Kirklees Metropolitan Council

Application Reference: 2025/91542

**Site: Erection of 40 dwellings and associated works, including formation of new
vehicular access and erection of cricket netting**

Sport England Reference: PA/25/Y/KK/71268

6. Proposed Cricket Net

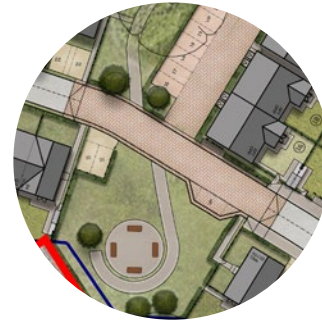
- *There is insufficient information as to how the ball stop netting can be accessed for management and maintenance purposes.*
- *The ECB continue to object to this scheme until we can see revised plans which consider the whole ball strike risks.*

In addition, there is insufficient information provided regarding the design and construction of any proposed ball stop netting. There is also insufficient information on how it would be accessed for ongoing management and maintenance, which raises further concerns about the long-term effectiveness of the mitigation.

site boundary. This should also include details of how any ball strike mitigation will be managed and maintained. Any ball strike mitigation provided should not have any encroachment onto the existing playing field/cricket ground. There should be no expectation that any maintenance and management is undertaken by the cricket club or other sport users. This should be undertaken by the applicant.

The below diagram shows the proposed locations of the recommended mitigation for heights detailed above to prevent 95% of cricket ball trajectories from impacting the proposed development if played on all currently used pitches:

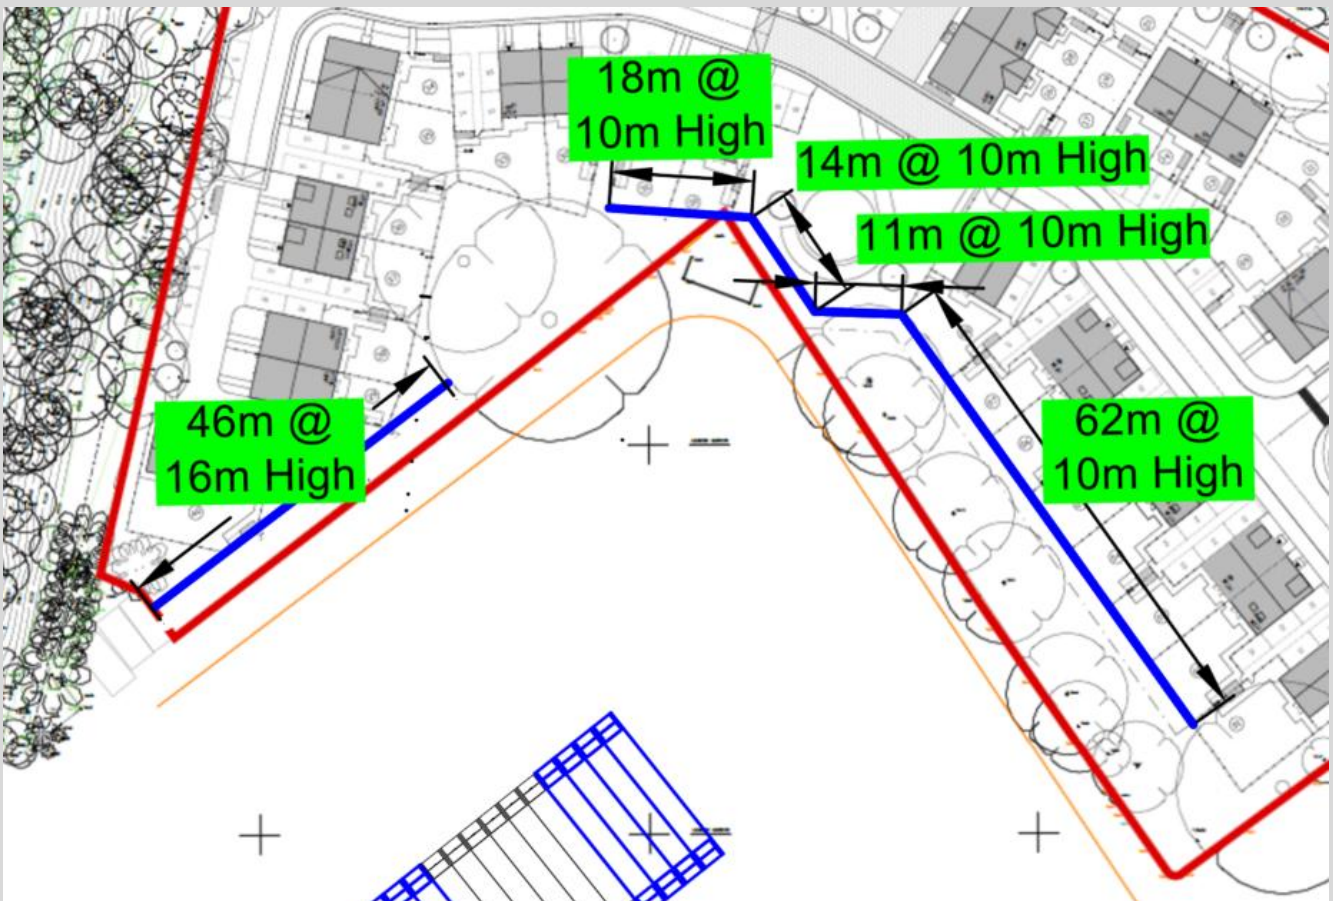
- *Revised ball strike risk assessment reduces the height of the mitigation required from the previous report. It appears the variable here is the metric now being used of 95% protection rather than "vast majority" of protection. There is no reasoning attached to that amendment and therefore we consider that unacceptable as additional risk would be transferred to the cricket club.*

- *Our previous comments regarding the ball stop netting not covering the whole development site appear to have not been attended to and therefore we continue to object on that basis. Mitigation should cover the whole development site and trees cannot be used as mitigation. Individuals walking through the grounds will be at risk.*

Sport England notes that the revised ball strike risk assessment now applies a 95% level of protection. However, no justification has been provided for adopting this approach in place of the previous assessment method and level of protection. The ECB consider this proposal represents a reduction in the level of protection and would result in additional risk being transferred to the cricket club, which is unacceptable.

Furthermore, our previous comments regarding the extent of the proposed ball stop netting do not appear to have been addressed. The current proposals do not provide mitigation across the entirety of the development site, and therefore individuals moving through the area would remain at risk. It should also be noted that existing trees cannot be relied upon as suitable mitigation.

1. A revised ball strike risk assessment*, undertaken by a suitably qualified consultant, that examines the ball trajectory for cricket for the entire site boundary with the cricket ground. The assessment should clearly address the concerns of the ECB.
2. If ball strike is identified as an issue, then clear and full details of the proposed design, specification and layout of any ball strike mitigation (for example ball stop fencing/netting) should be provided and for the entire
